SSD-10448-MOD2 – RESPONSE TO TRANSPORT FOR NSW COMMENTS

This letter is provided to the Department of Planning and Environment (DPE) in response to the Transport for NSW (TfNSW) comments received (TfNSW ref: SYD19/01350/46 dated 2 Sep 2022) for the Aspect Industrial Estate (AIE) SSD-10448-Mod 2 in relation to the design of the location of Warehouse 1 access driveway off Road 1.

DESIGNED RebeccaBMadden	PAPER SIZE A3	CLIENT Mirvac	DOCUMENT INFORMATION	
APPROVED BY X.XXXX	DATE 03.03.2022	PROJECT 1897	DESIGN ASSESSMENT	
SCALE 1:3000	NTS	Lots 54-58 Mamre Road, Kemps Creek	GENERAL NOTES	
			FILE NAME AG1897-01-v05.dwg	SHEET AG01

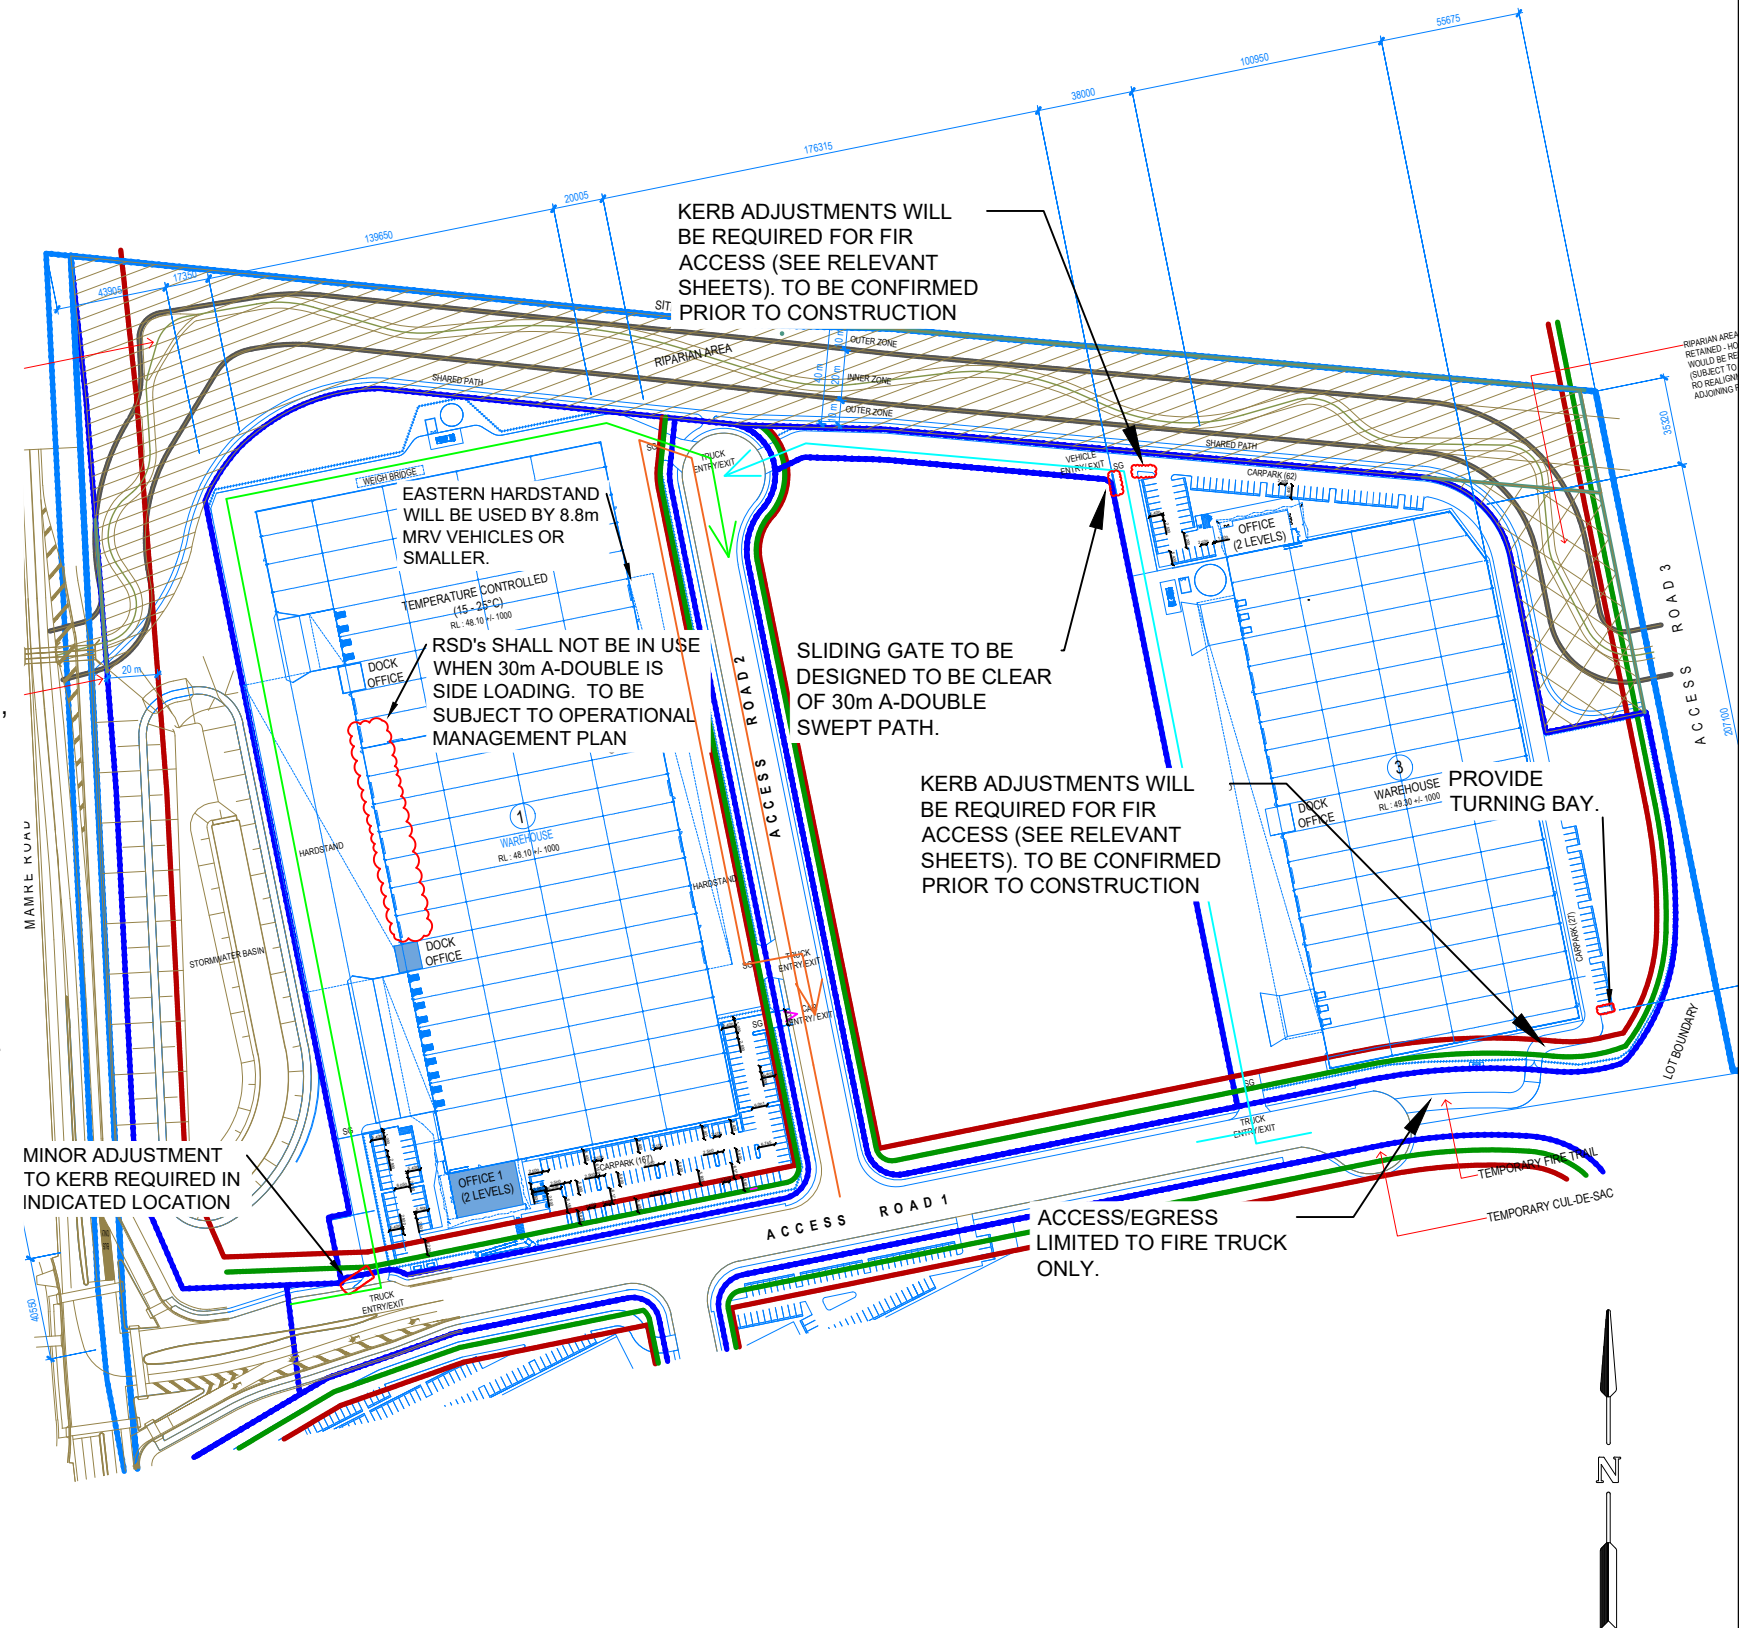
In addition, the short length and width of the deceleration lane does not adequately accommodate for a 26m B-Double or 36.5m PBS Level 3 type A vehicle and therefore long vehicles will not effectively utilise the lane.

Please advise why the proposed driveway location / requirement for warehouse no.1 clockwise circulation

Condition A9 of SSD10448 restricts the largest vehicle permitted to enter the site as a 30.0m PBS Level 2 Type B. This is the design vehicle for the intersection and the estate. Refer table 1 below.

- If warranted, the required length for a deceleration / diverge lane as per Austroads (Part 4A Table 5.2) for a 60km/hr design speed is 55m.
- The deceleration / diverge lane length for **exhibited Mod 2 Warehouse 1 driveway** (refer Appendix 2) was 60m with a distance from the signalised intersection stop line of 36m.

- The deceleration / diverge lane length for **revised Mod 2 Warehouse 1 driveway** (refer Appendix 3) is 83m with a distance from the signalised intersection stop line of 36m.

- The **revised Mod 2 Warehouse 1 driveway** location would facilitate an Austroads compliant deceleration / diverge lane length of 55m (design speed of 60km/hr) with a distance from the signalised intersection stop line of 64m (refer Appendix 3B). This distance is greater than the desired minimum of 50m (as required) in greenfield sites as raised by Rachel Cummings from TfNSW.

- One-way traffic flow is required in a clockwise direction to maintain the safe accepted industry practise of 'right hand down' reverse access to docks and support efficient and safe process flow of goods throughout the warehouse.
- The proposed site layout and circulation pattern prevents two-way traffic movements on the hardstand which would be a suboptimum outcome from the Warehouse 1 customer (CEVA) from a safety perspective; and
- The proposed access arrangements also removes the need for Warehouse 1 heavy and light vehicles to exit onto Road 1 and allows relocation of car access to Road 2.
